Application Correspondence "Arrangements for Tree Protection Measures Inspection"

Subject: BN/39/20/PL - Condition 10. Pre-commencement site meeting for 17th February, 9:30am.

I confirm my attendance and look forward to assessing the approved tree protection measures, as shown on the Tree Protection Plan, dwg. no. ECO 3 (Appendix 1 of the Arboricultural Implications Assessment and Method Statement, Ref: 181087-AIA, 27/02/19).

ECO 3 - TREE PROTECTION AT TARS FARM, CHURCH LANE, BARNHAM

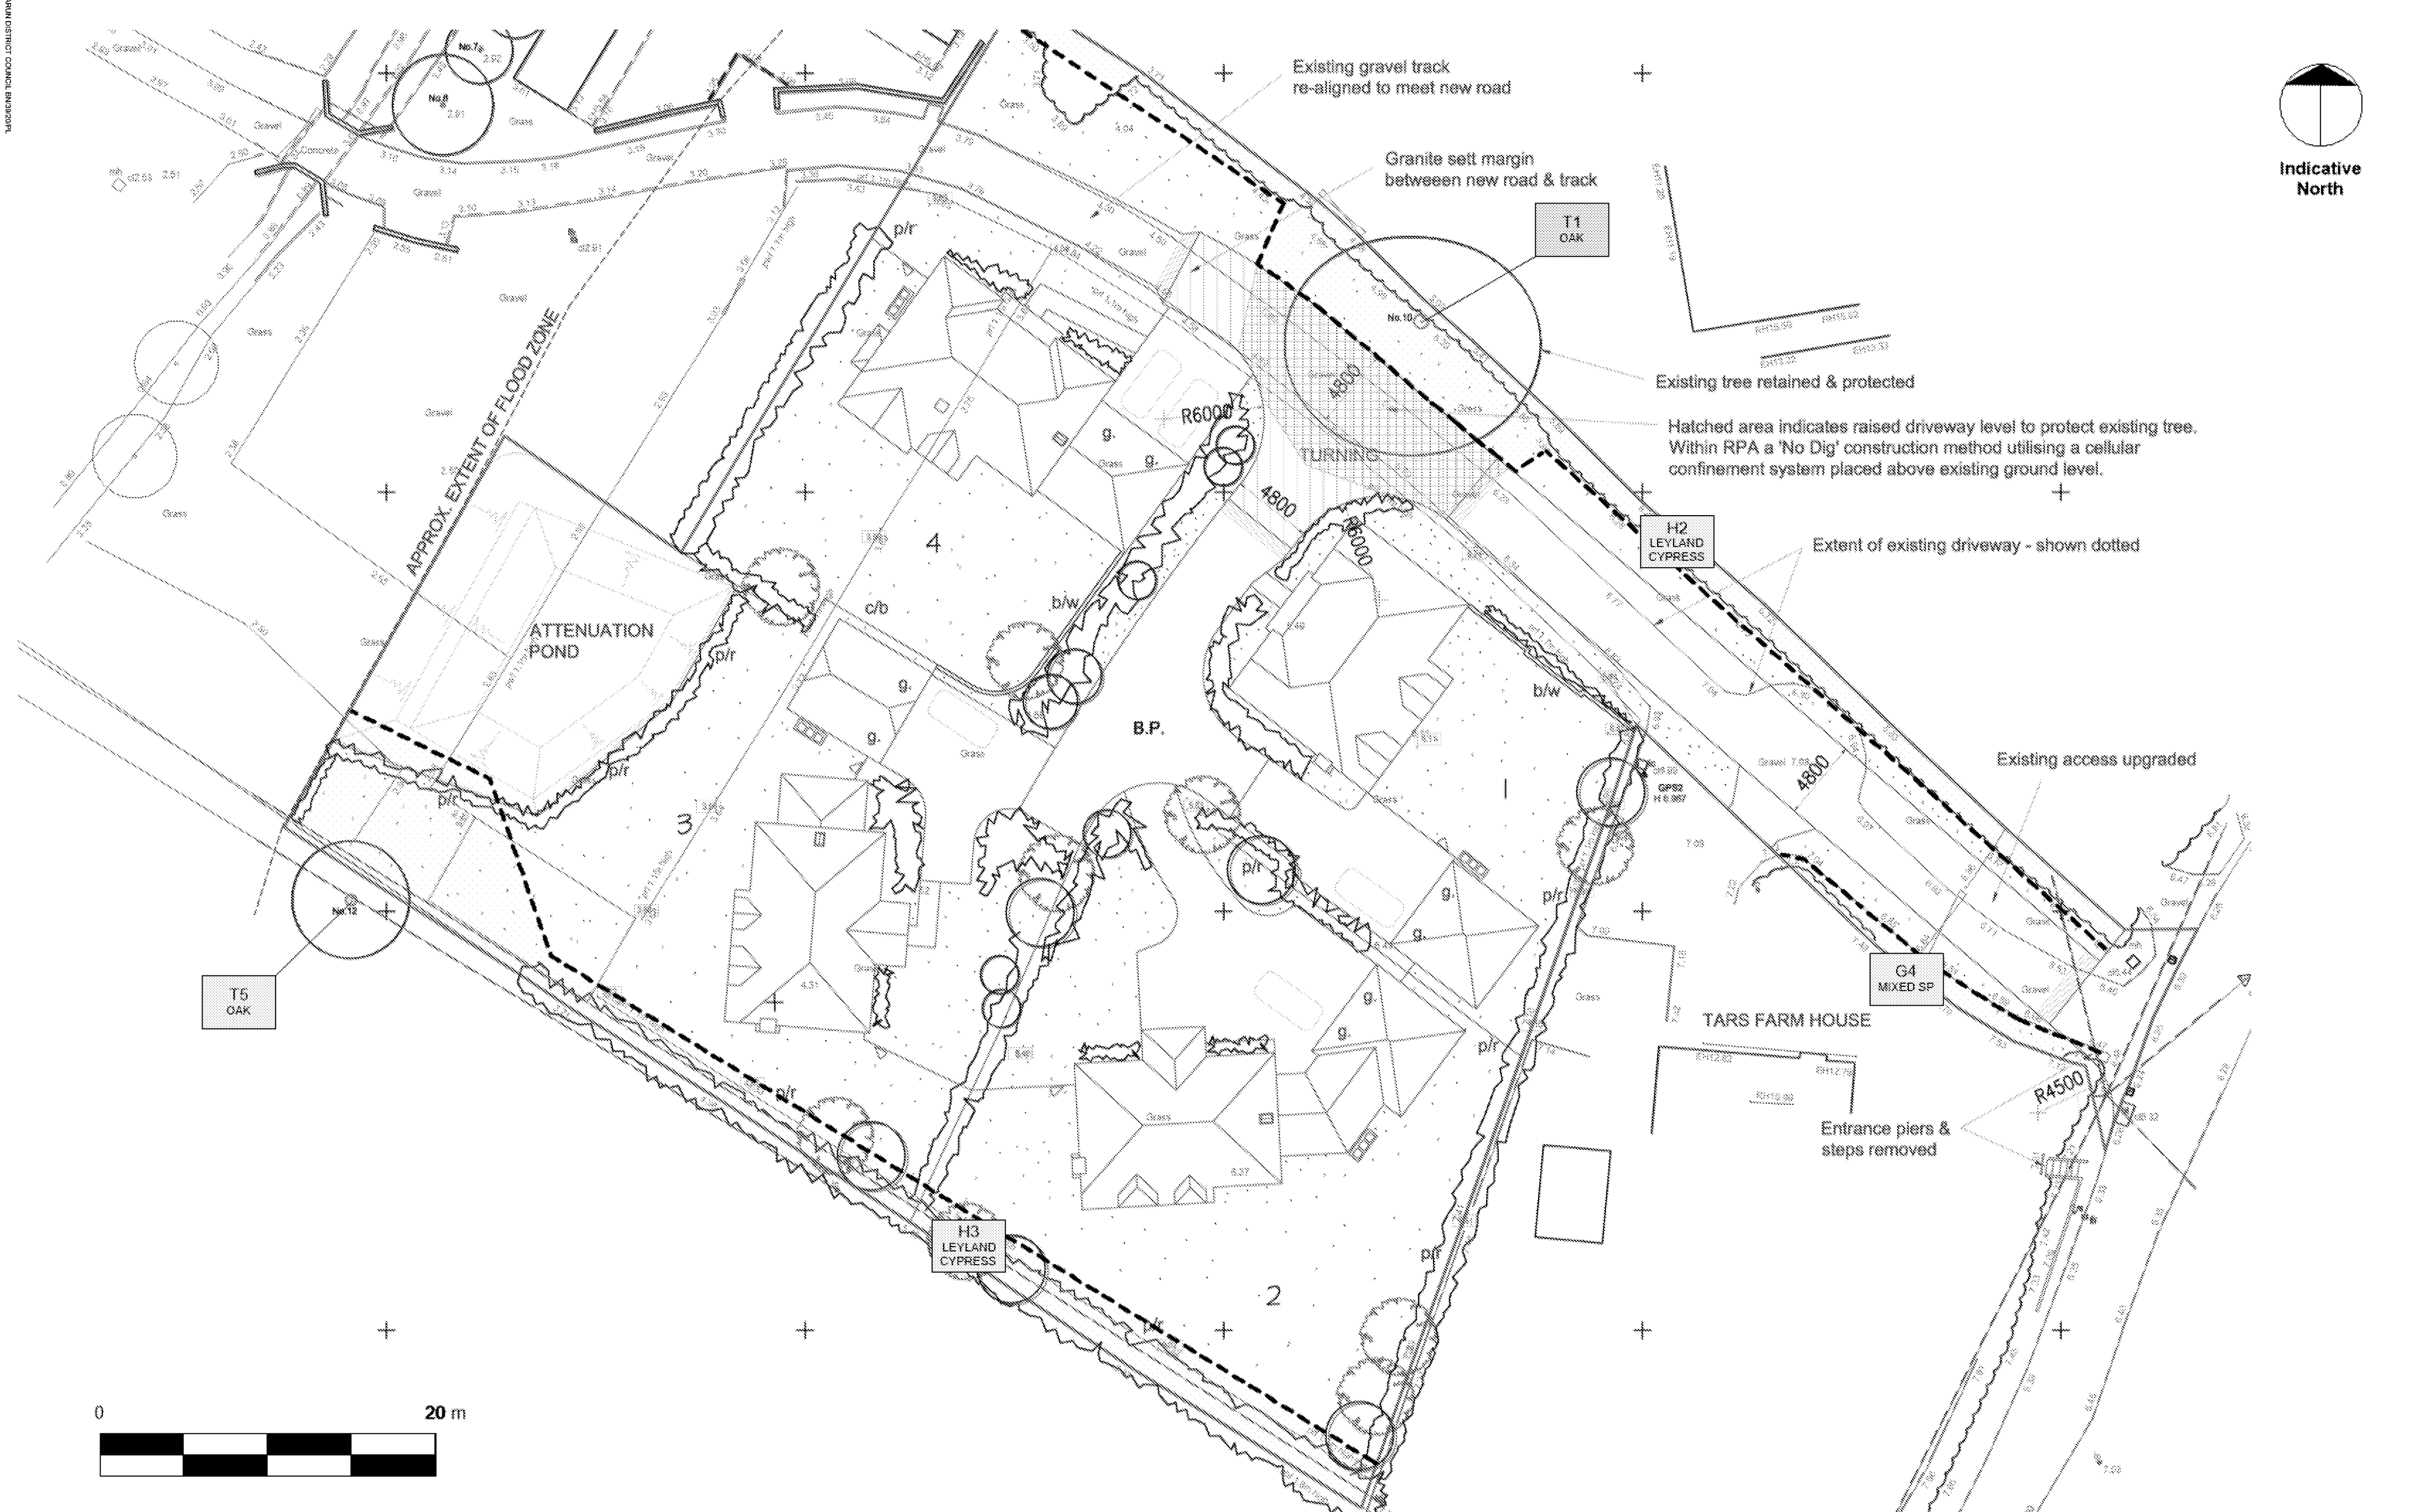
Should any of the tree protection measures be outstanding or incomplete then clear photographic evidence of the necessary refinements and brief written report confirming the same from your project arboriculturist, will need to be submitted for approval prior to commencement.

At this stage I draw special attention to T1 Oak that is the subject of a Preservation Order. To prevent damage occurring to this high value tree and to ensure strict adherence to the Method Statement (condition 9), supervised removal of existing track and installation of the 'No-dig' construction within T1 root protection area (RPA) is required. I recommend you seek further advice from the project arboriculturist if not already. In the meantime it could be helpful to revisit the following sections in the report 5.2.2, 5.2.3 and 5.3.5.
